May 9, 2022  
File No. 21-004.200

**Subject: Response to City of Mercer Island Comments  
Temporary Cut Slopes, South Side Excavation  
9611 SE72nd Street  
Mercer Island, WA**

Geotechnical Addendum  
9611 SE 72<sup>nd</sup> Street  
Mercer Island, Washington  
May 9, 2022

SH2.1

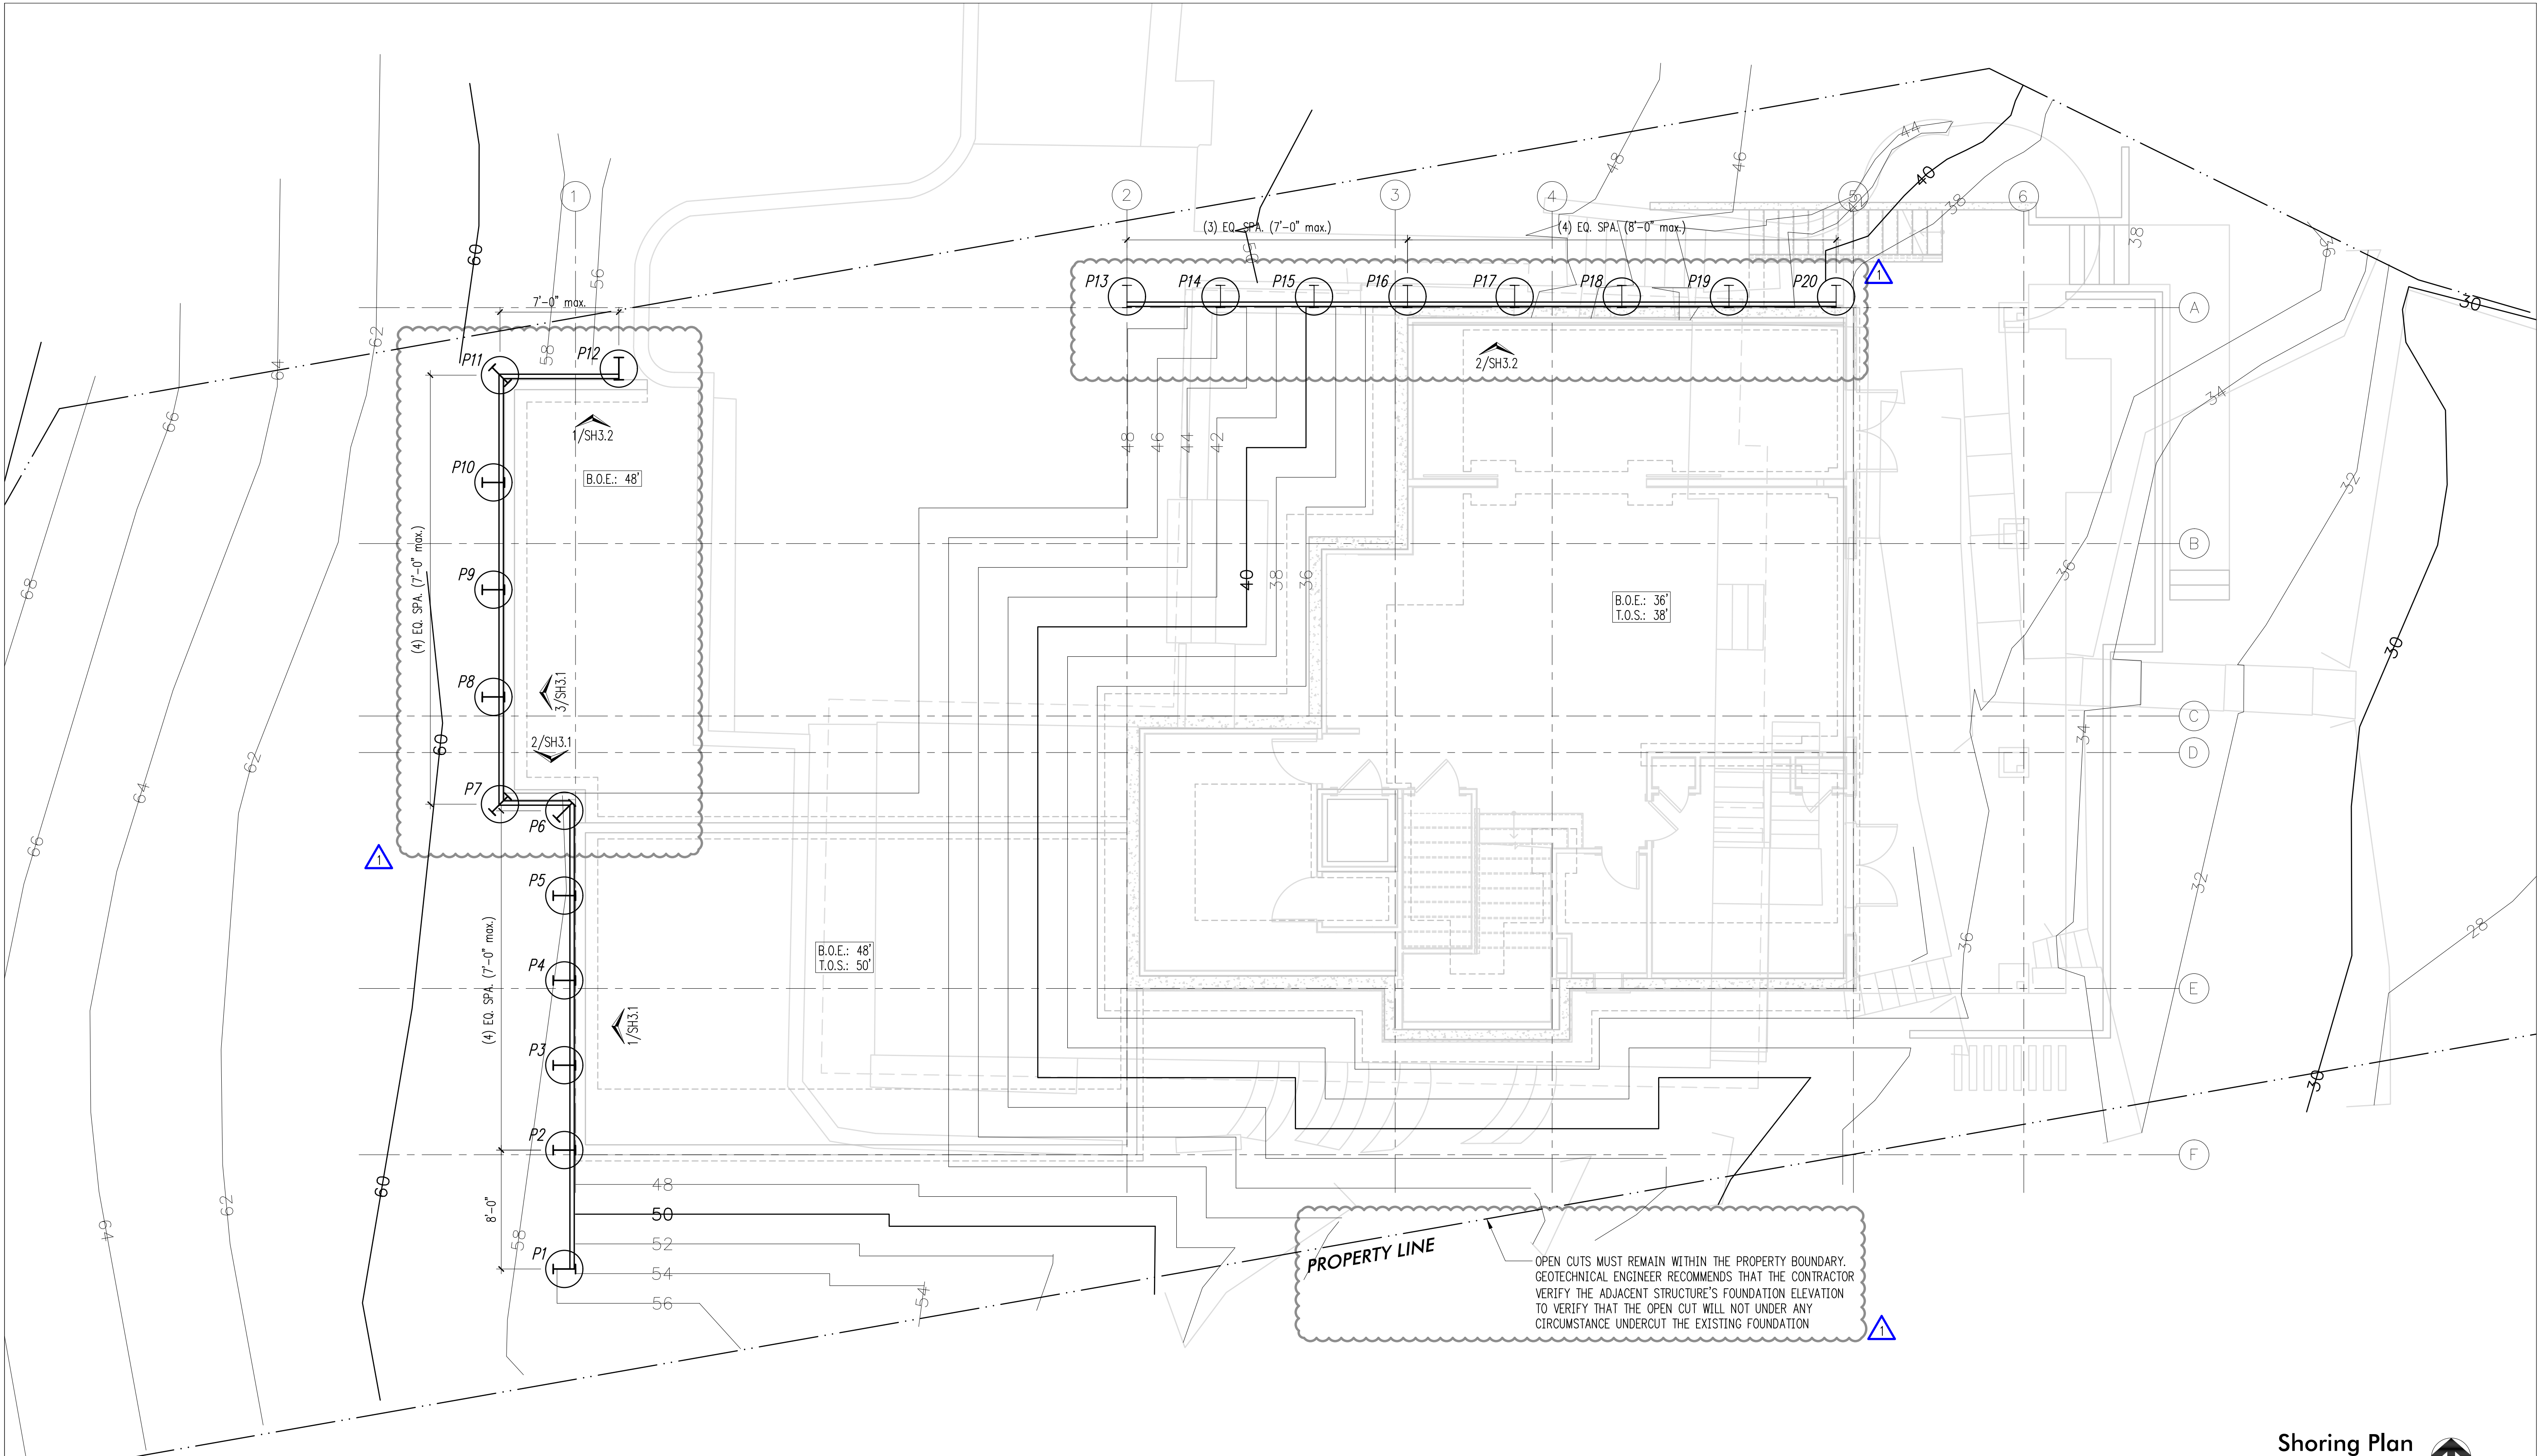
This letter provides response to the review document from the City of Mercer Island dated May 5, 2022, regarding sheet SH2.1 and the proposed 1H:1V temporary cut slopes on the south side of the excavation. In our opinion, temporary cut slopes graded at 1H:1V are acceptable along the south side of the excavation, so long as the cut remains within the property boundary of the subject site, and as long as groundwater does not adversely affect the excavation. We recommend that the contractor be prepared to install well points or sumps should groundwater impact the stability of the excavation cut slope.

Temporary cuts that are contained within the boundaries of the subject property are unlikely to negatively impact adjacent properties. Nonetheless, to mitigate the possibility of future claims we recommend that, before excavation starts a baseline survey of nearby structures be carried out, and that additional surveys be conducted weekly to verify that no impact has occurred.
